From: [Holly Duncan](#)
To: [Jeff Watson](#)
Subject: RE: BL-10-00030 Carpenter
Date: Monday, July 26, 2010 10:10:09 AM

carpenter

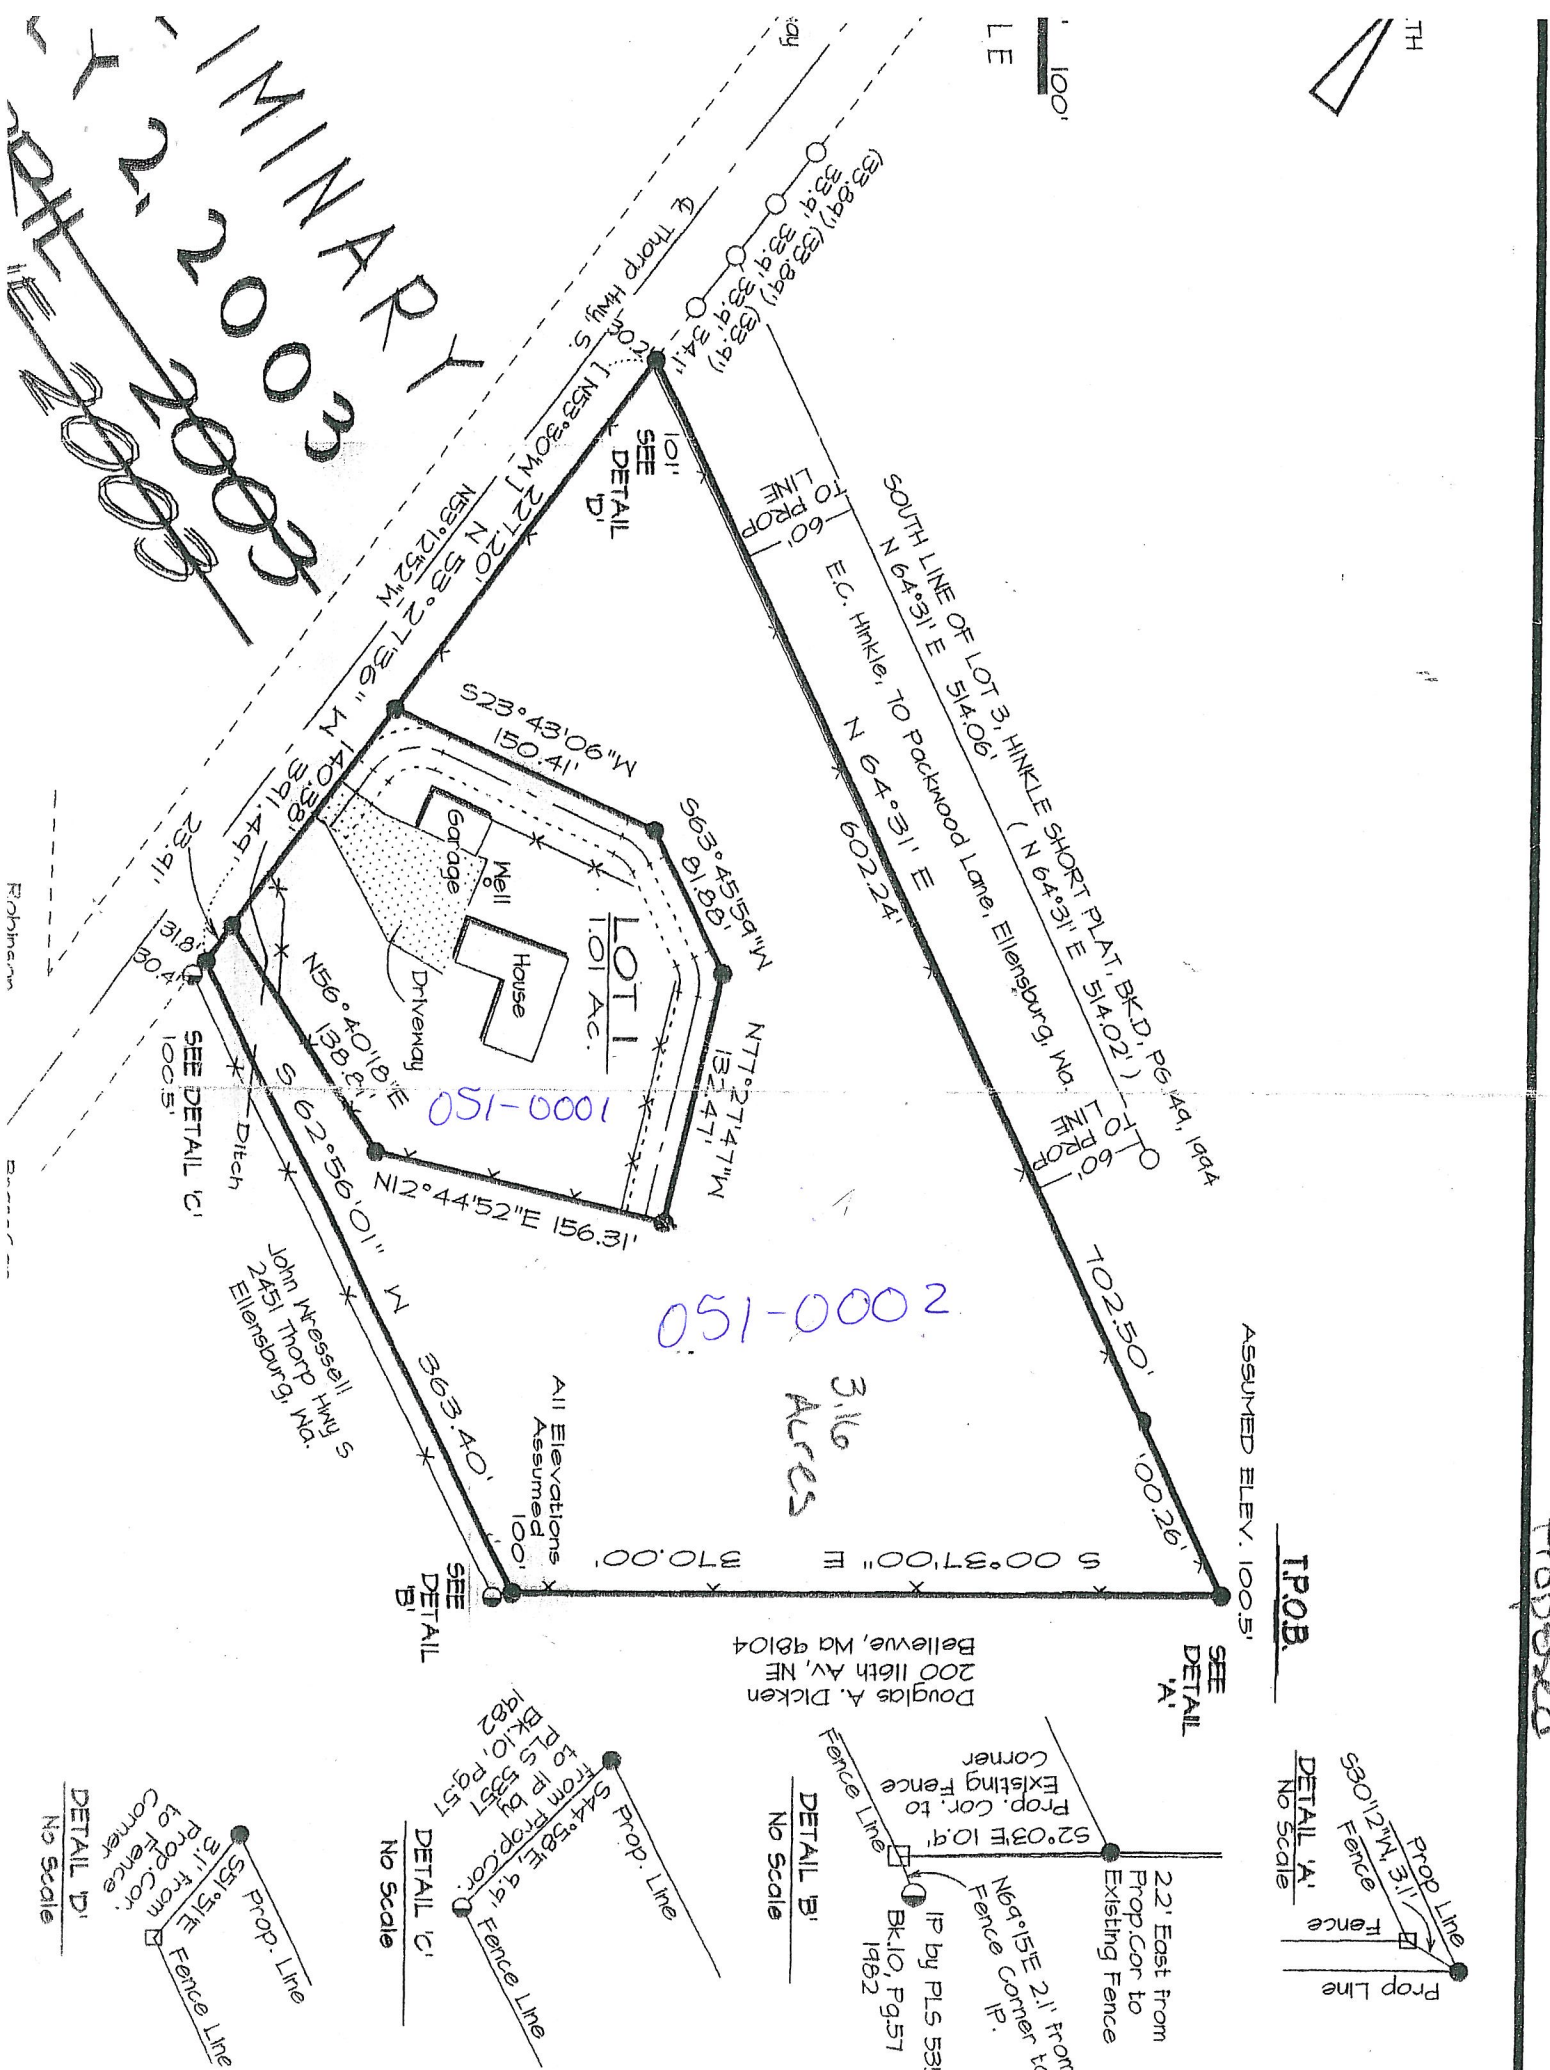
The well must be 50 feet from the proposed property line. The drawing doesn't show the distance that will be.
